Our Case Number: ABP-317121-23

Re: BusConnects Swords to City Centre Bus Corridor Scheme
Swords to Dublin City Centre

ABP case ref: 317121

BUSCONNECTS SWORDS CORE BUS CORRIDOR SCHEME

Drawing File Name: BCIDB-JAC-TSM_GA-0002_XX_00-DR-CR-0005 | Sheet Number: 05 of 37 | Status: A | Rev: M01

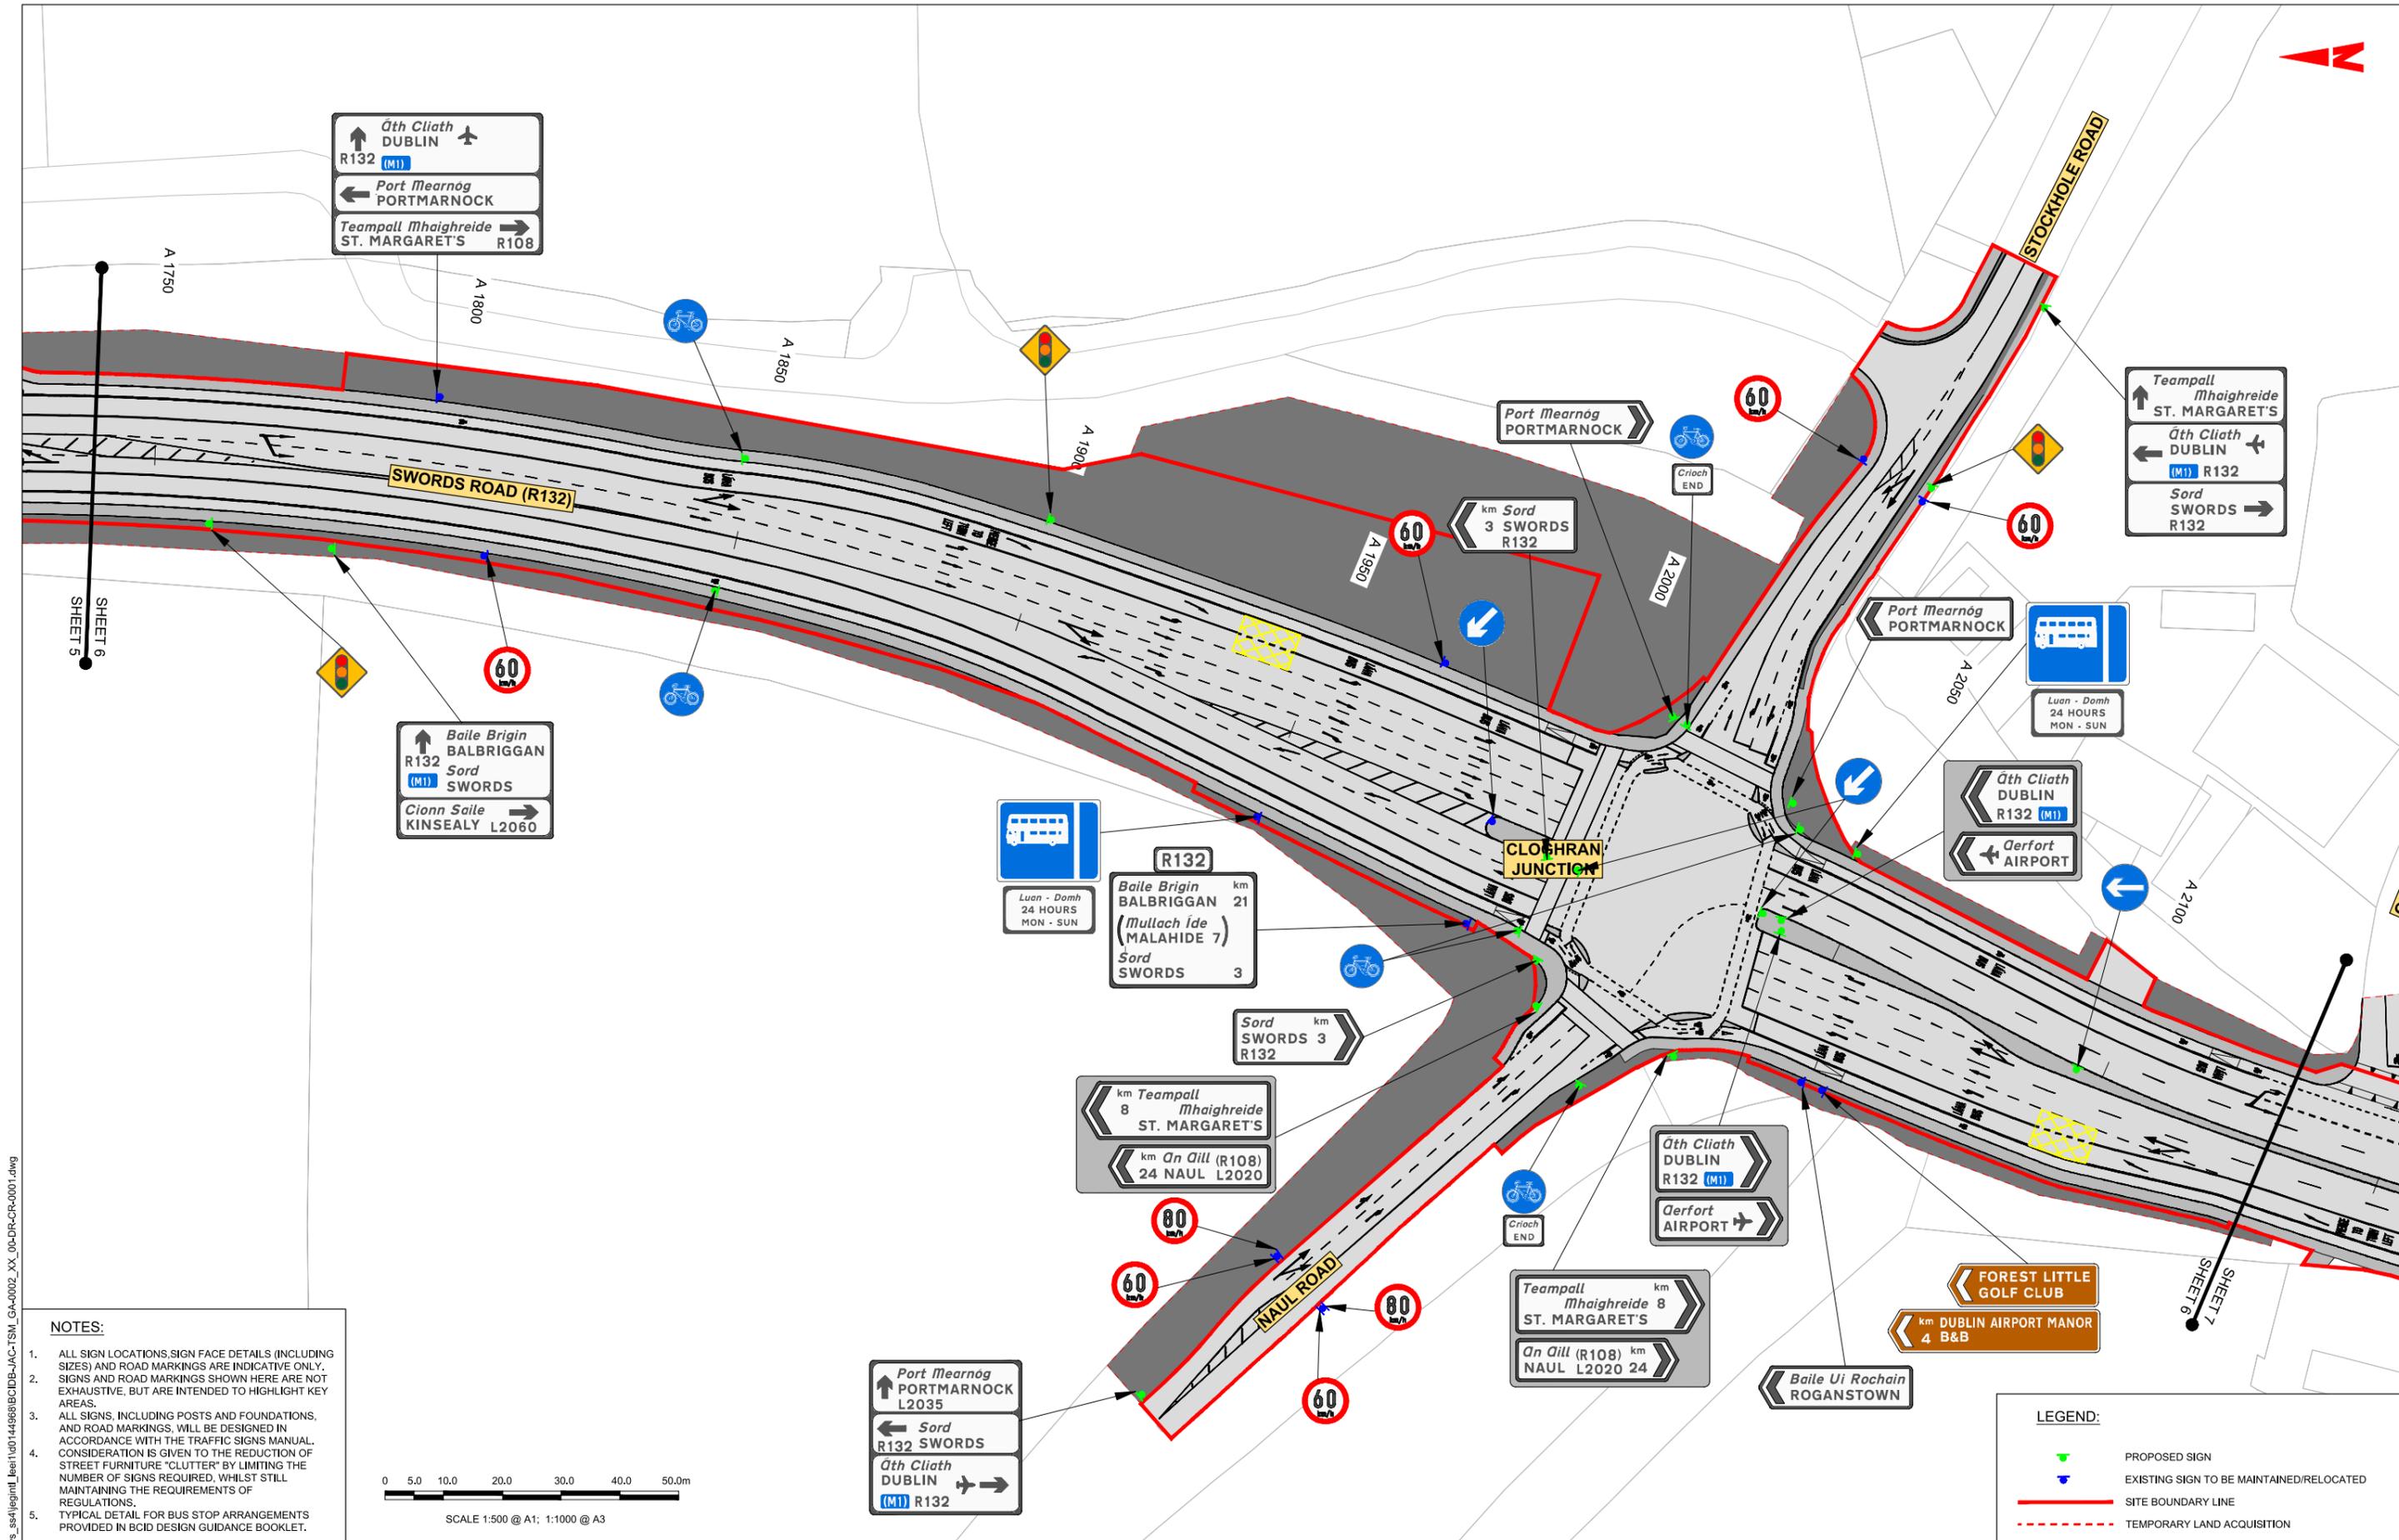
- Kettles Lane (sheet 5)
- Cloghran Junction (6)
- Long term parking/Kealy's Pub (9)
- Old Airport Road (12)
- Quick Park (12)
- Coolock Lane (18)
- Seven Oaks (28)
- Millmount Ave (31)
- Botanic Avenue (31)
- Clonliffe Rd (33)
- Whitworth Rd (33)
- Belvedere Road (34)

Programme Title BUSCONNECTS DUBLIN CORE BUS CORRIDORS INFRASTRUCTURE WORKS			
Drawing Title SWORDS TO CITY CENTRE CORE BUS CORRIDOR SCHEME TRAFFIC SIGNS AND ROAD MARKINGS			
Drawing File Name	Sheet Number	Status	Rev
BCIDB-JAC-TSM_GA-0002_XX_00-DR-CR-0009	09 of 37	A	M01

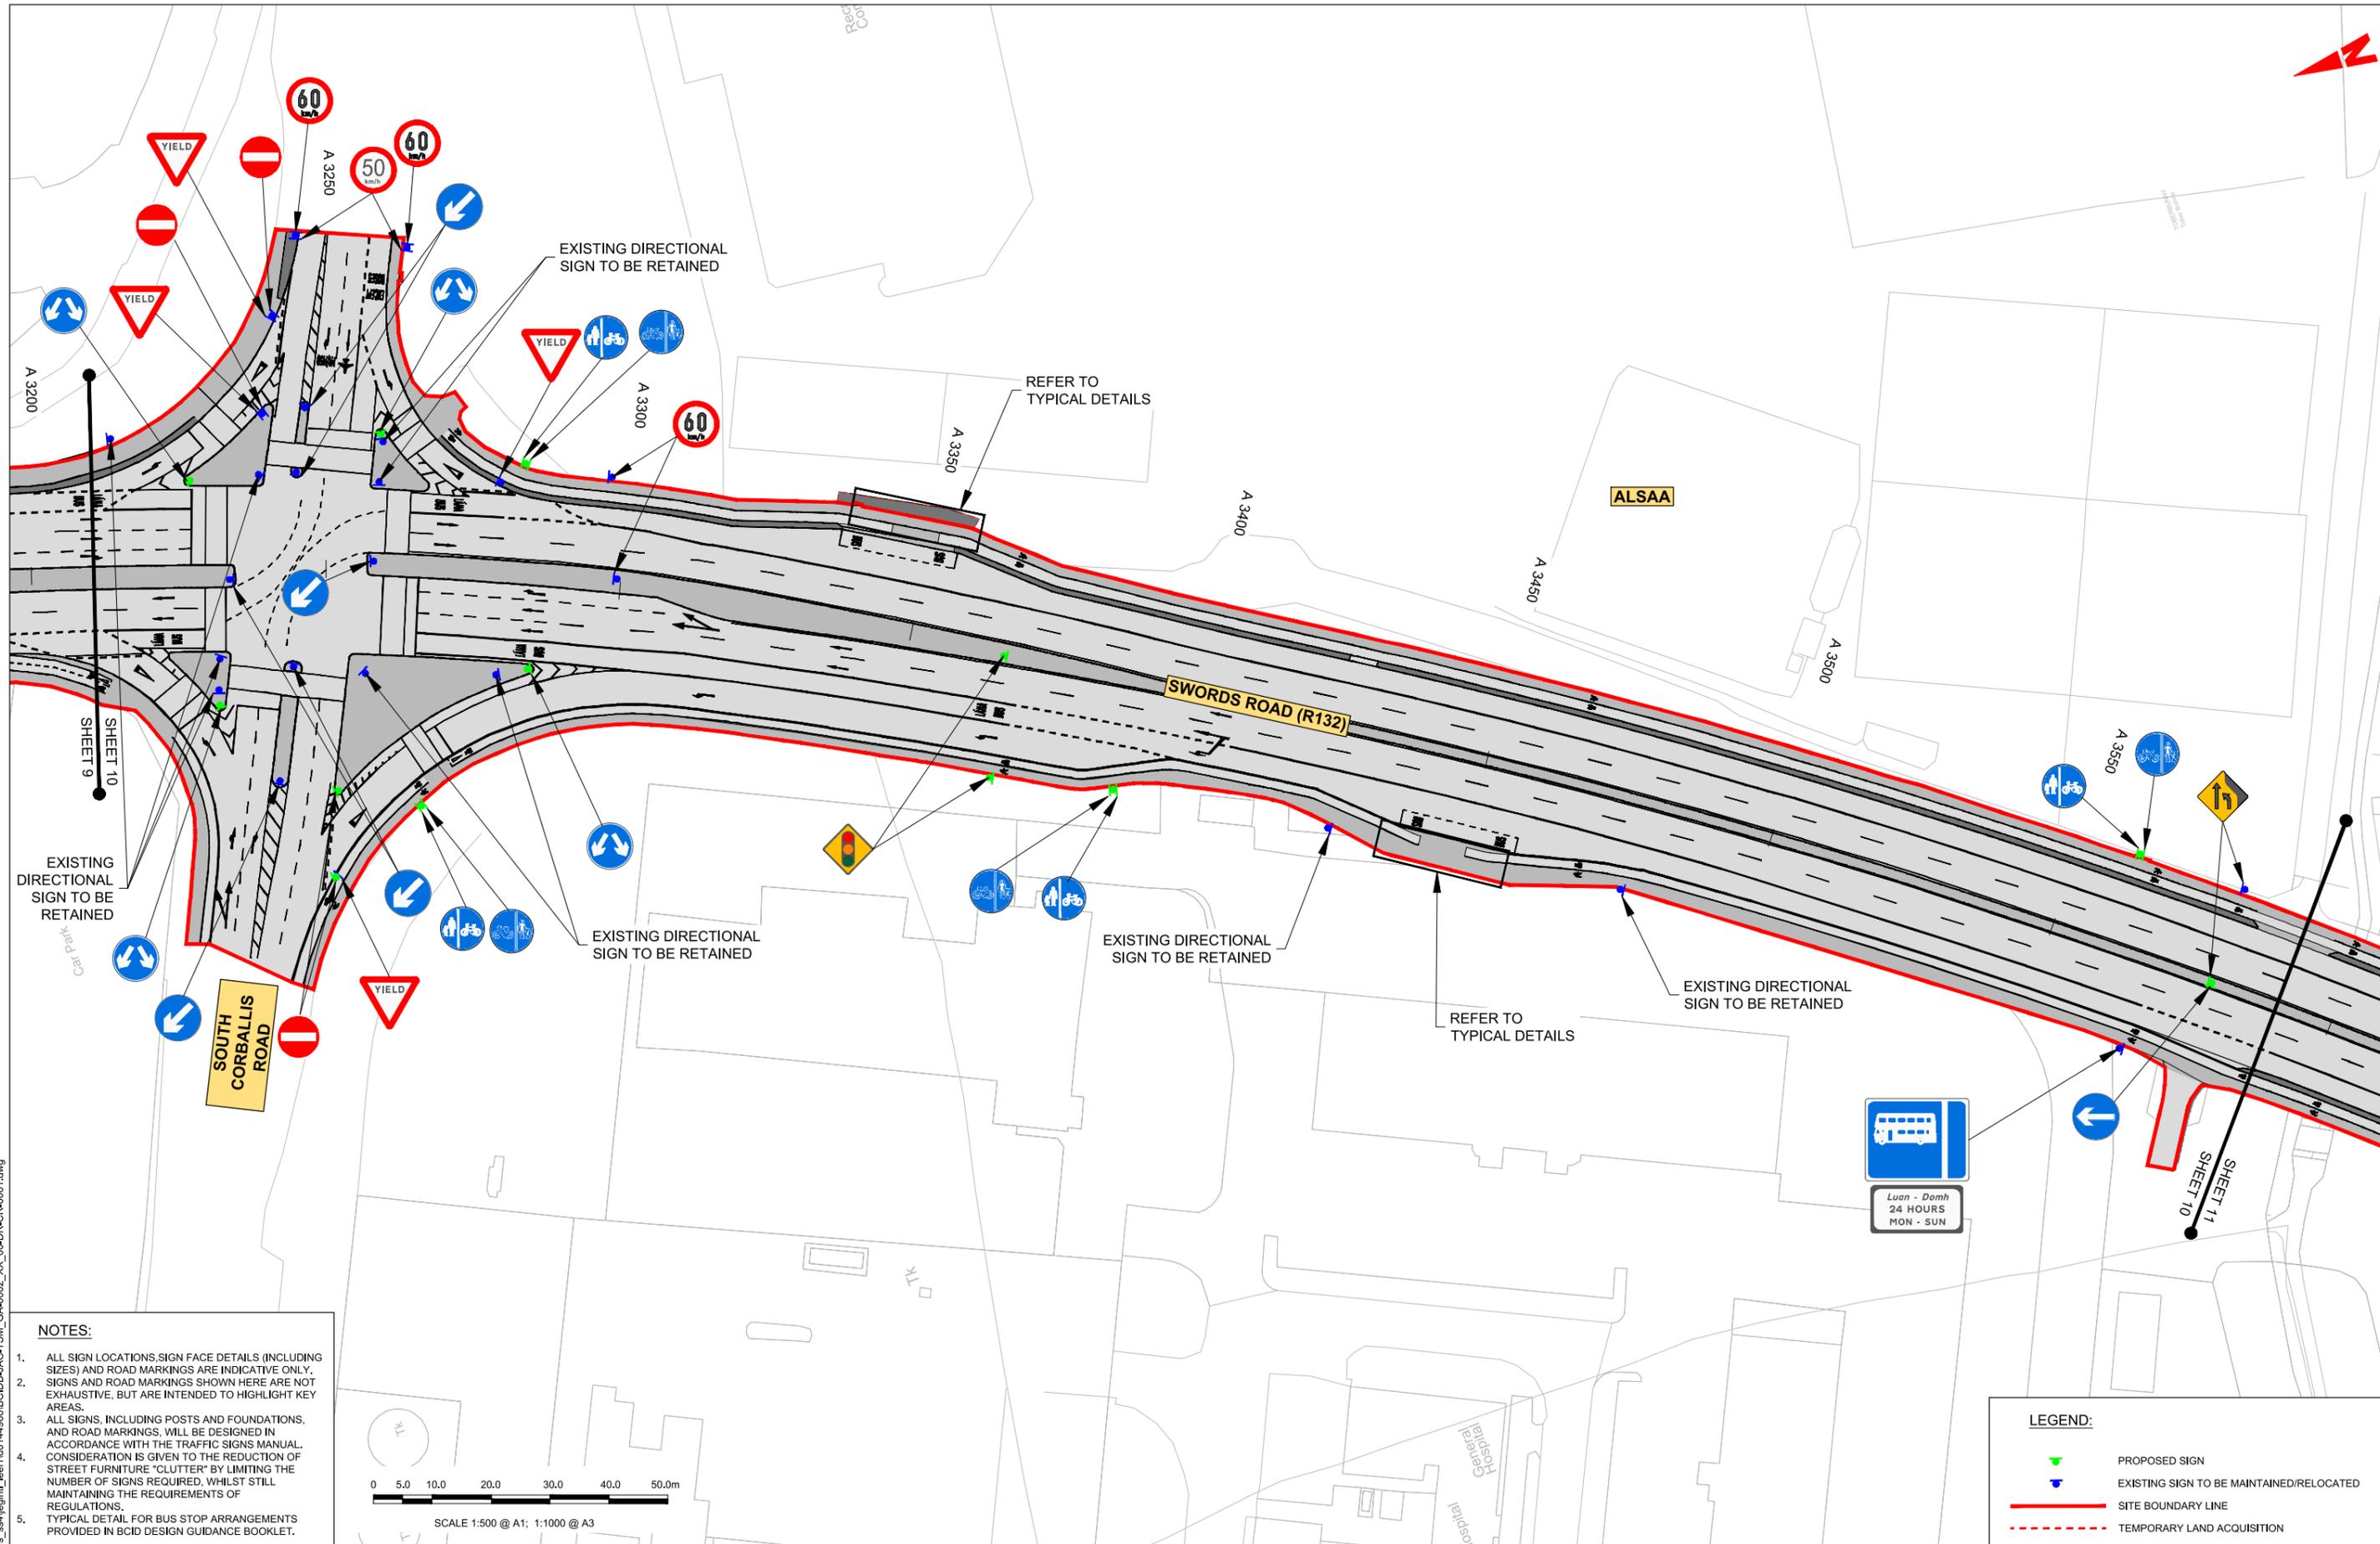
- Pinnock Hill Roundabout (sheet 1)
- Airside Junction (sheet 3)
- Cloghran Junction (sheet 6)
- Green Long Term Car Park (sheet 9) — 3 and 4 stage crossings with slip lanes
- South Corballis Road (10)
- Old Airport Road (12)

Programme Title BUSCONNECTS DUBLIN CORE BUS CORRIDORS INFRASTRUCTURE WORKS			
Drawing Title SWORDS TO CITY CENTRE CORE BUS CORRIDOR SCHEME TRAFFIC SIGNS AND ROAD MARKINGS			
Drawing File Name	Sheet Number	Status	Rev
BCIDB-JAC-TSM_GA-0002_XX_00-DR-CR-0010	10 of 37	A	M01

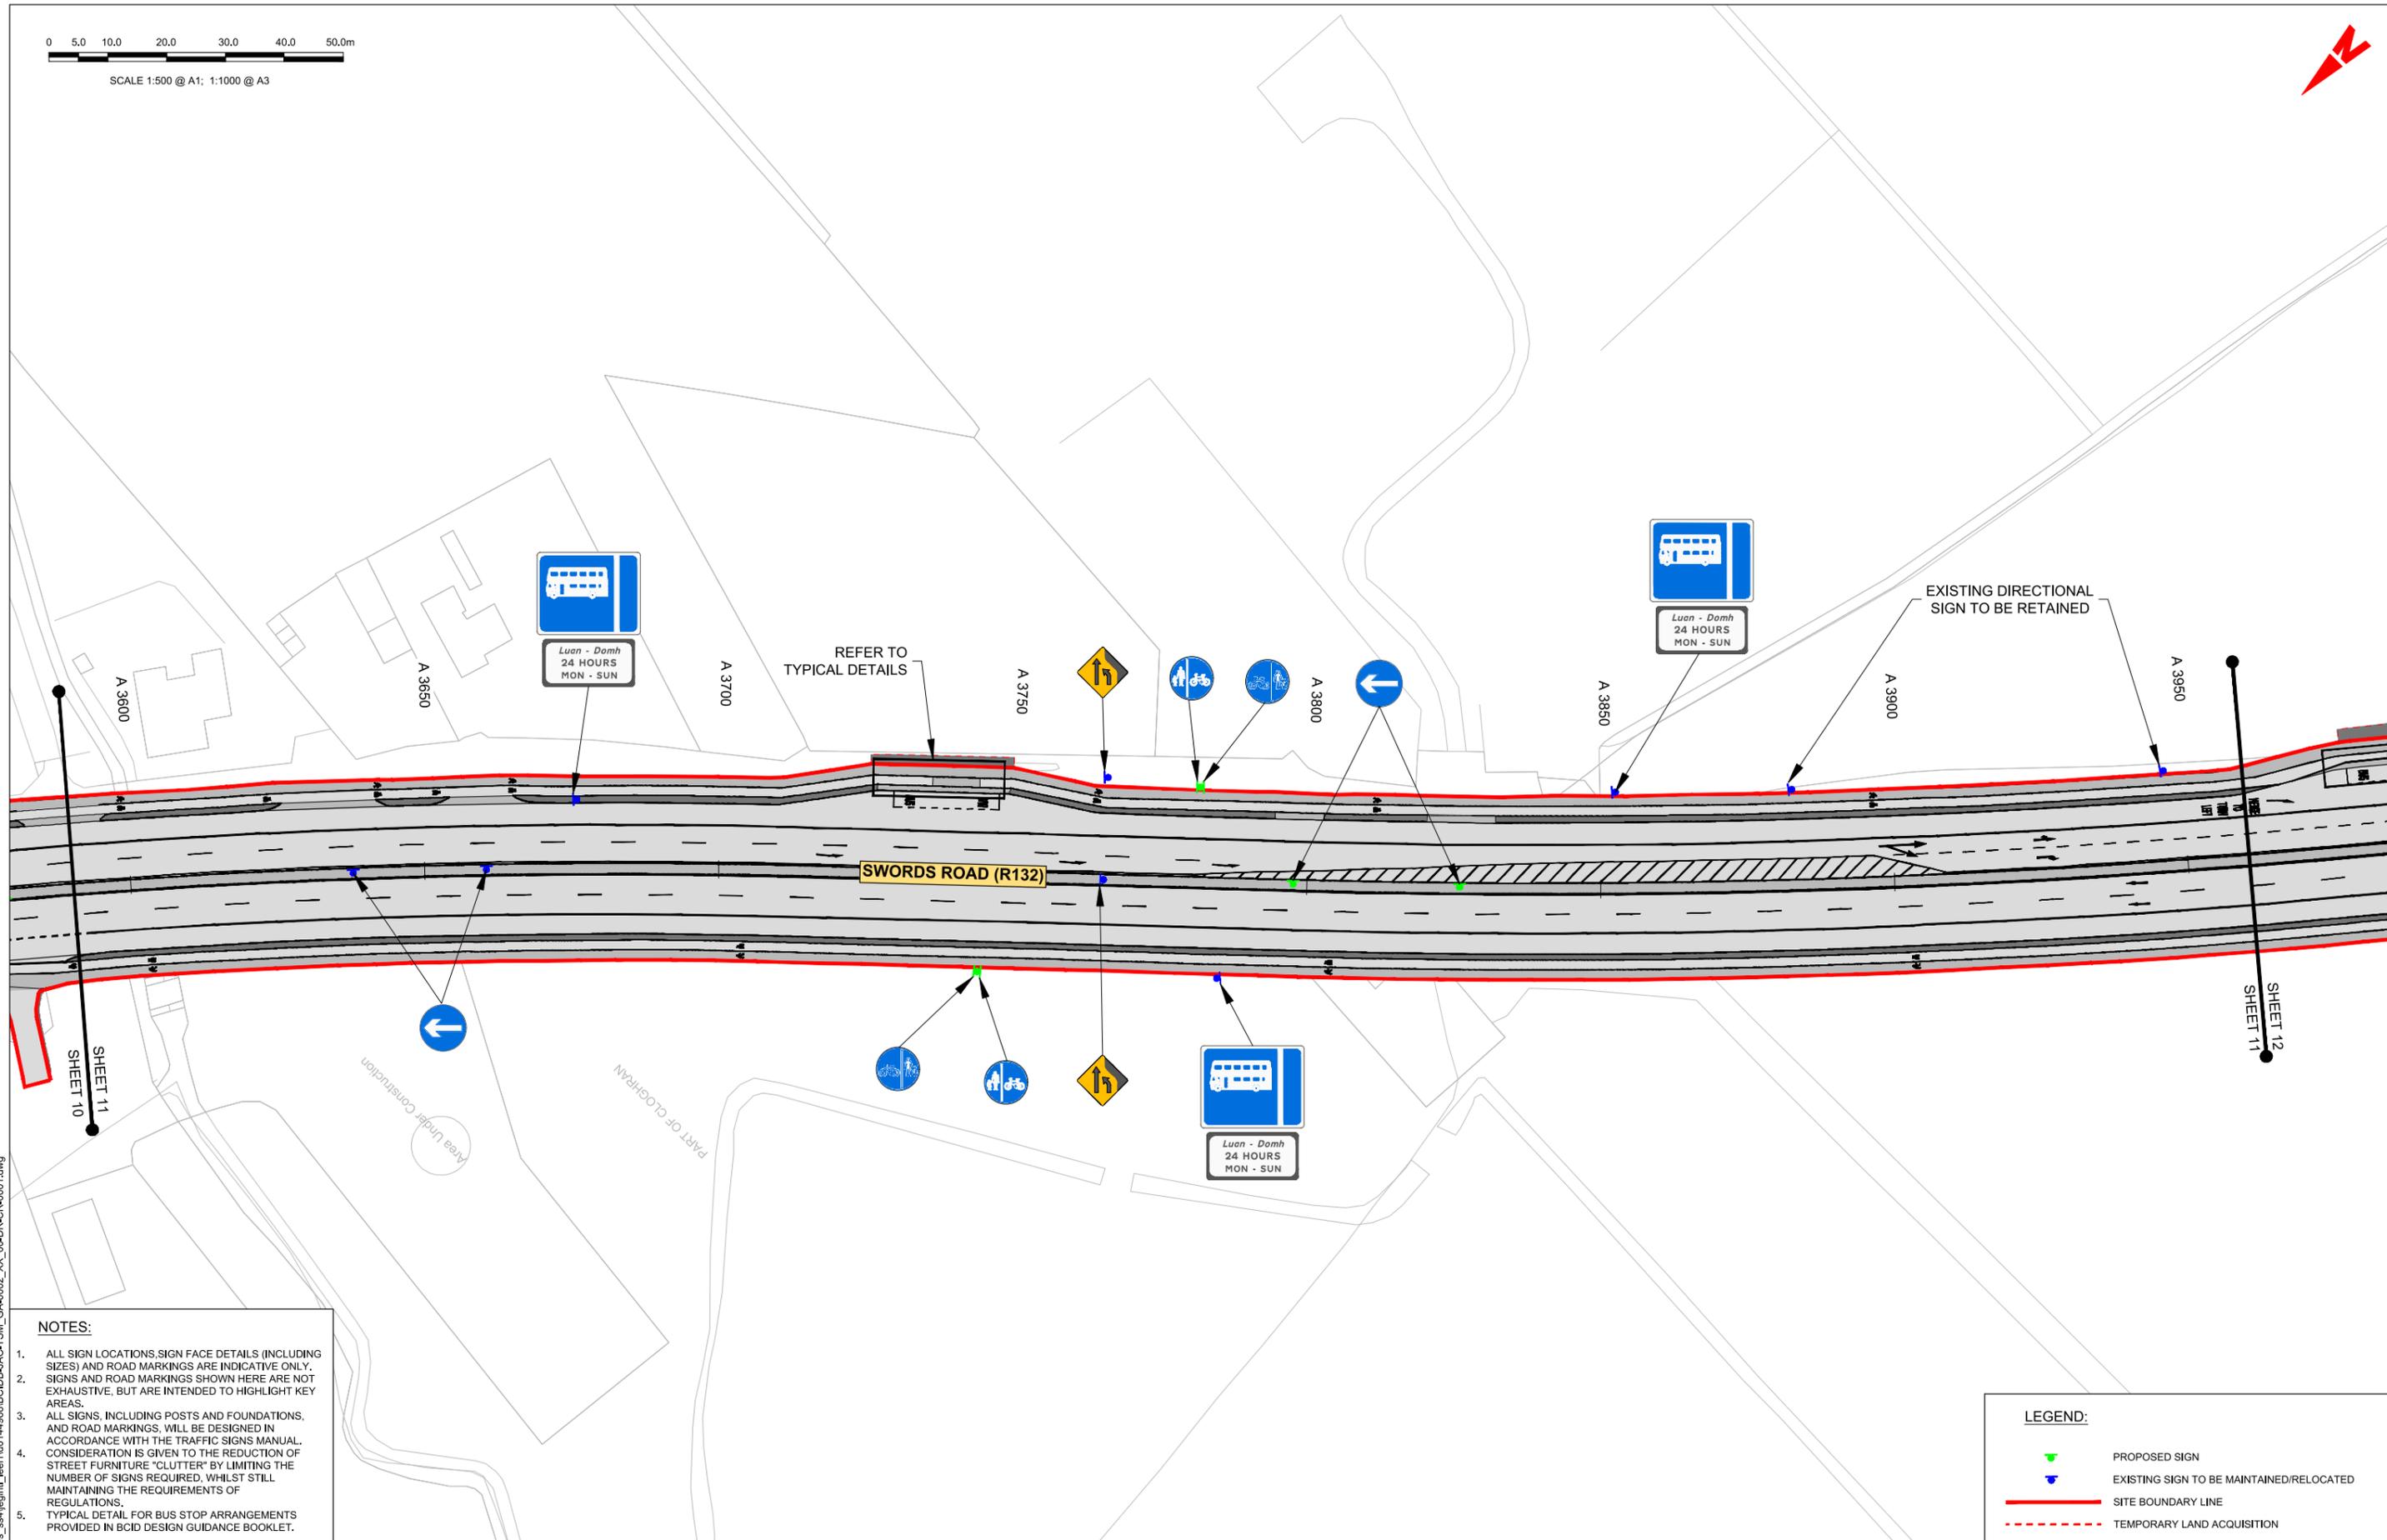
This junction is unsafe for pedestrians and cyclists and clearly does not enable sustainable modes of travel. Due to the provision slip lanes to prioritise turning car traffic, pedestrians have to make four crossings to get from one side of the road to the other and five crossings to go from one corner to the other. This could take over five minutes and is completely unacceptable. The southbound cycle lane on the western side of Swords Road ends at South Corballis Road and continues on the eastern side of Swords Road. There are 5 crossings between these points which is indirect and time-consuming.
